20170038.1/1007A/R0/TA

Western Sydney Stadium - SoundPLAN Noise Emission Modelling

This letter presents the supplementary SoundPLAN noise emission modelling to address comments raised by the EPA in their letter dated 27 June 2017.

$L_{max}$   
in dB(A)

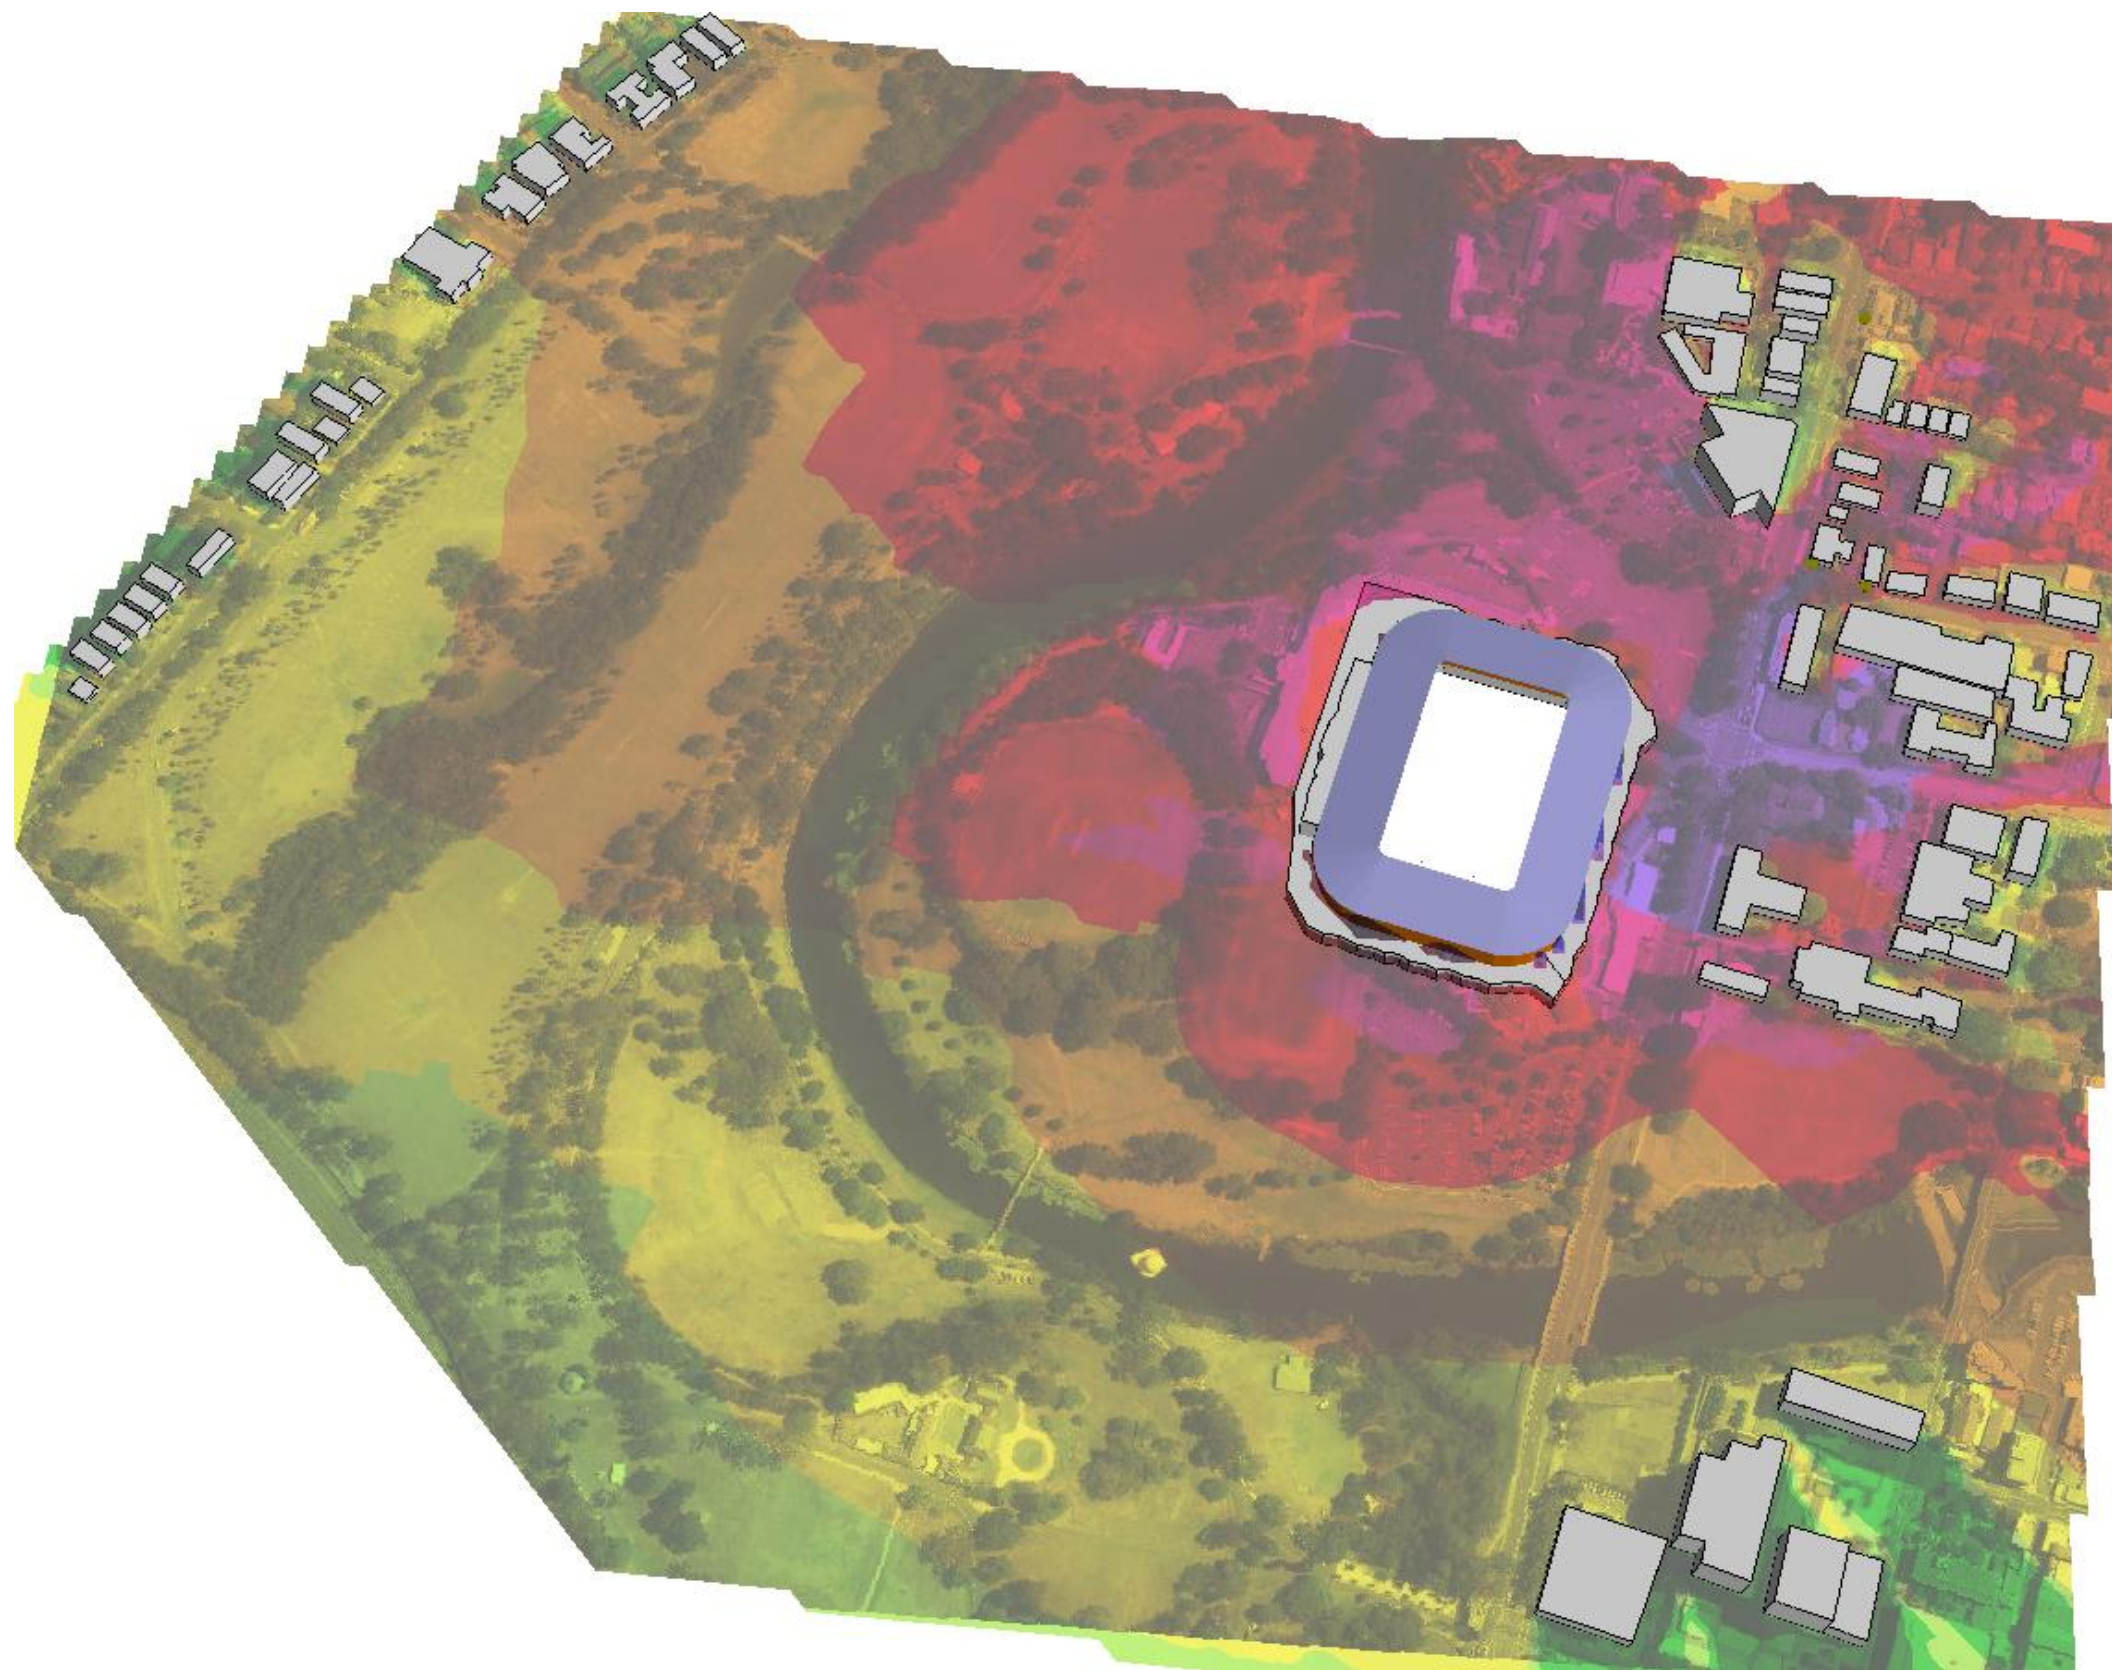
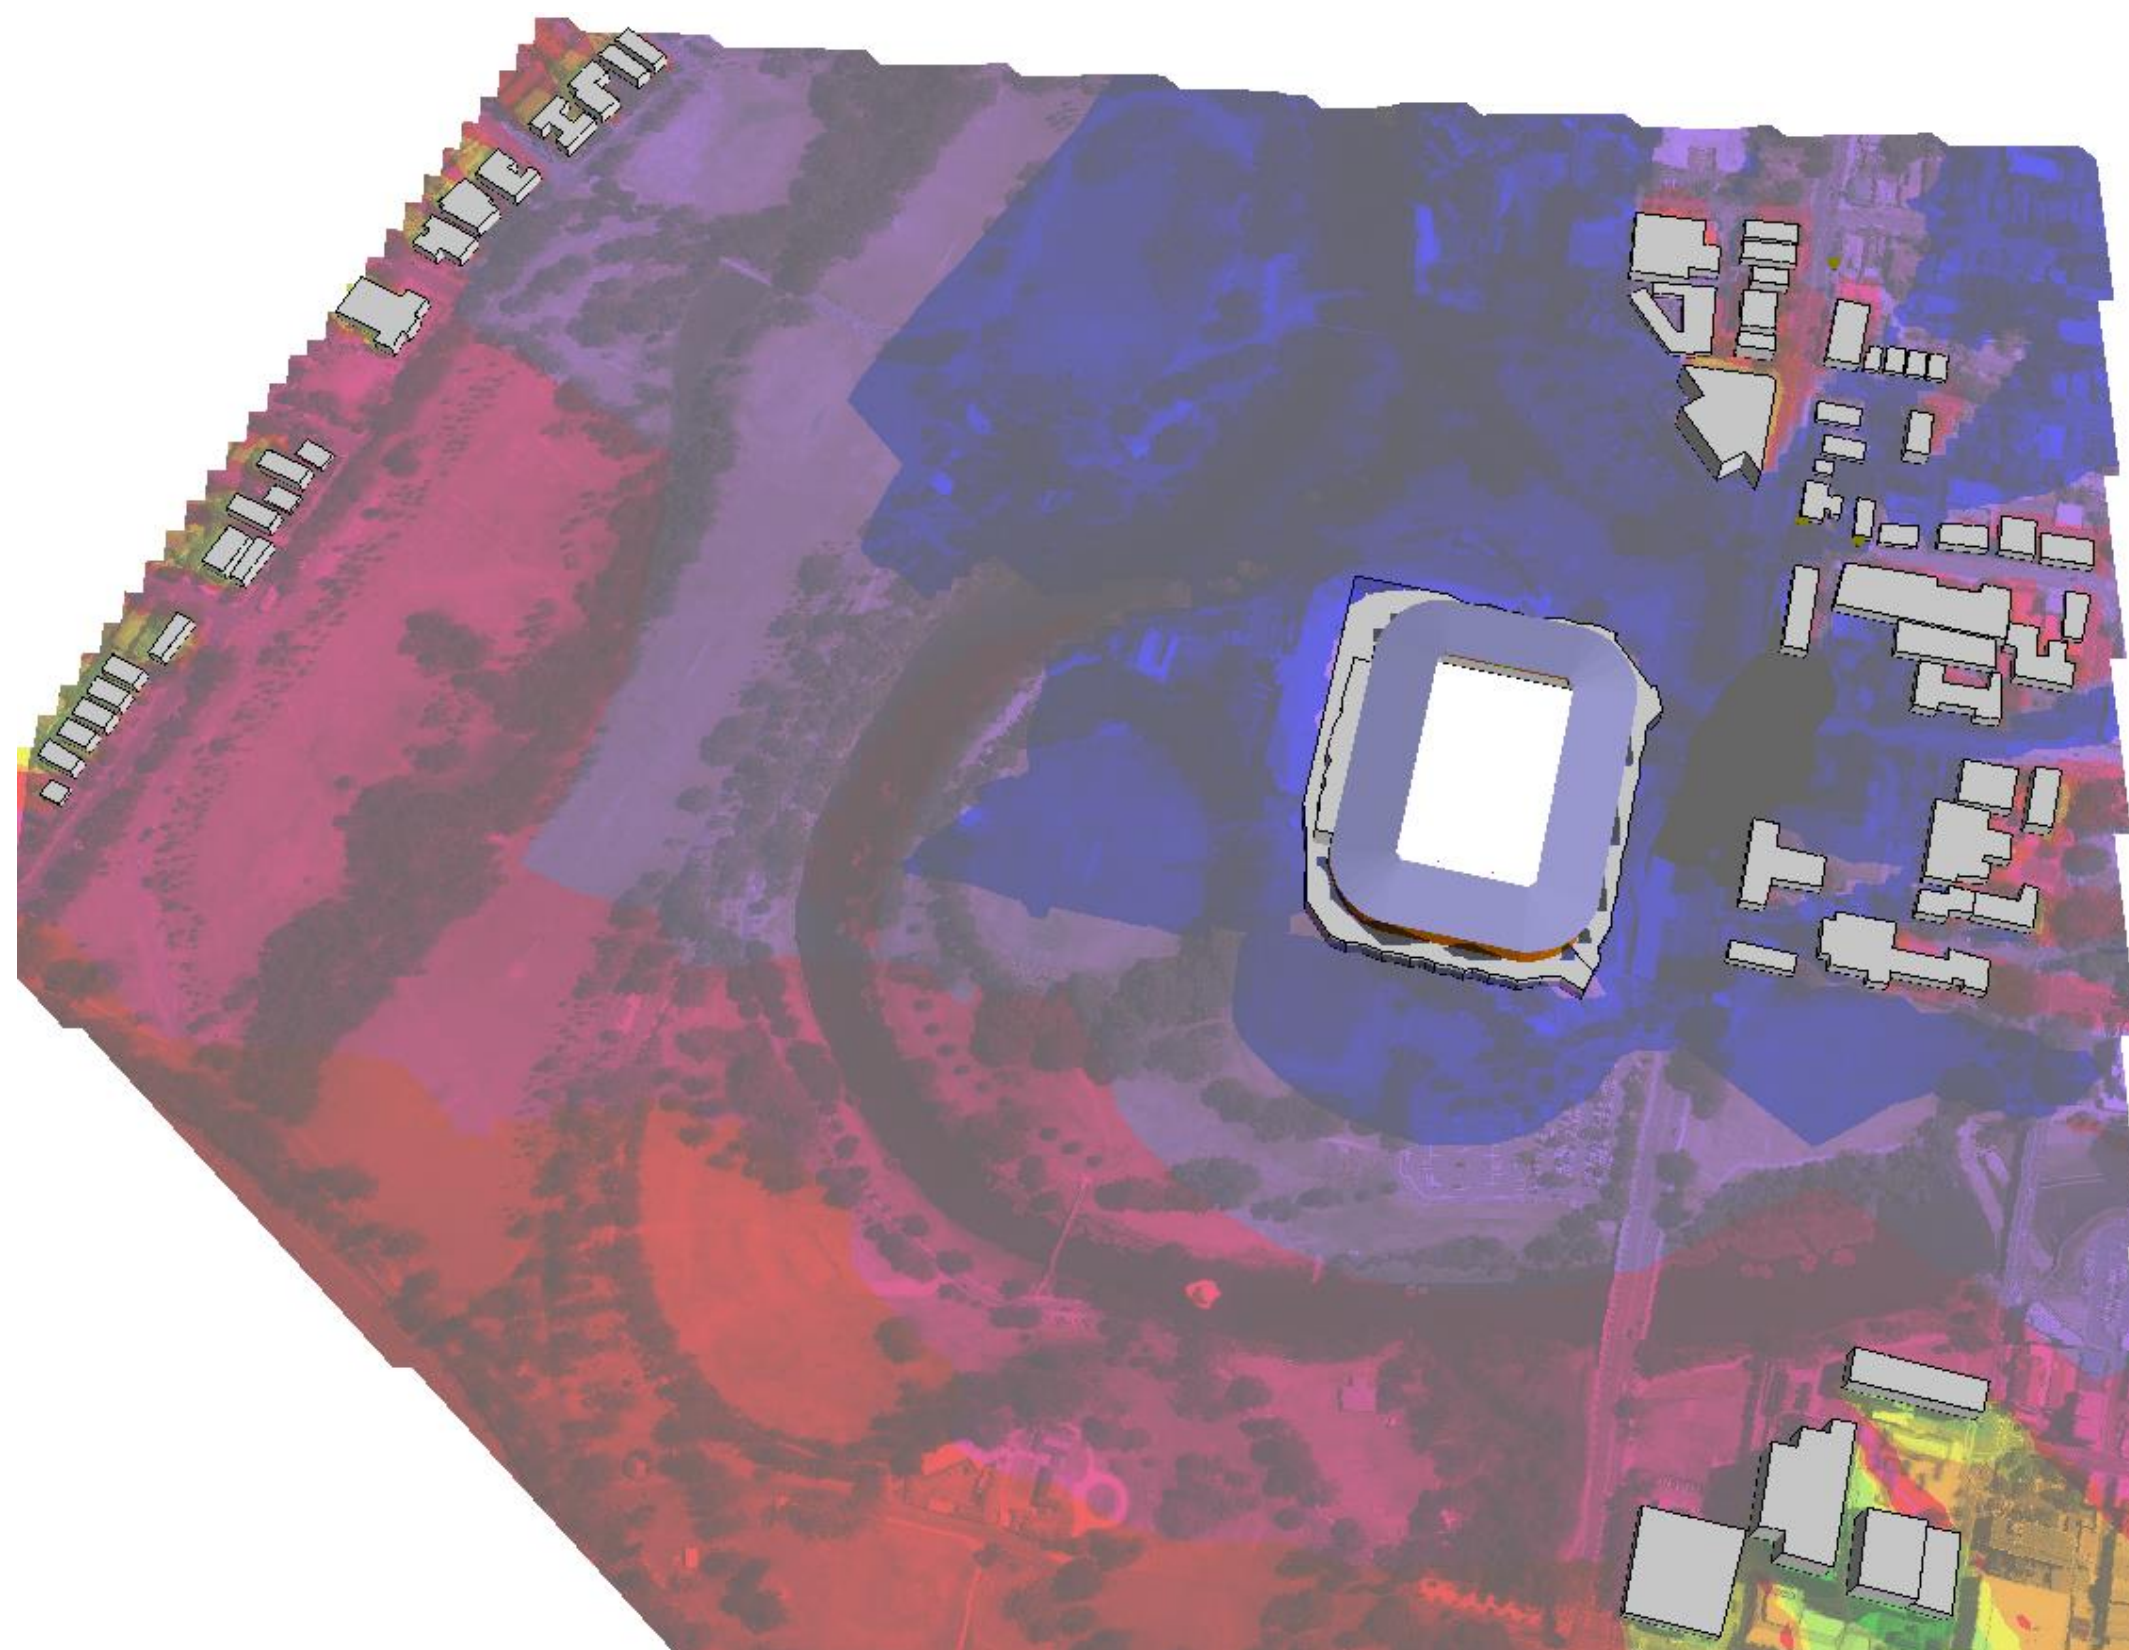
(a) provide a more detailed noise model of operational noise from the stadium, or other quantitative assessment, demonstrating that openings between seating tiers will not result in event noise being higher than predicted at sensitive receivers

The response to submissions did not demonstrate that all feasible and reasonable noise mitigation measures were included in modelling concert noise (for example, relocating the stage to face south, not north).

The openings between the seating tiers have been modelled and are presented as an isolated noise model in Appendix One. The predicted noise level contribution from the openings between the seating tiers is 64dB(A) at the nearest residential receivers in concert mode, 15dB(A) below the originally predicted noise level from the stadium as a whole, 78dB(A). As the contribution from the openings between the seating tiers is more than 10dB(A) below the predicted noise contribution of 78dB(A) from the main stadium, there is no increase in overall predicted noise level.

The stage has been relocated to the northern end (facing south). The results of this modelling are presented in Appendix Two. Modelling results indicate noise levels of 70dB(A) L_{eq} (including the contribution from the gaps between the seating tiers) for noise emissions during concert mode to receivers to the north. Previously these noise levels were predicted to be 78dB(A) L_{eq} with the Stage facing north.

The stage is now proposed to remain in this location, facing south, reducing noise emissions to the nearest residential receivers situated on O'Connell Street.
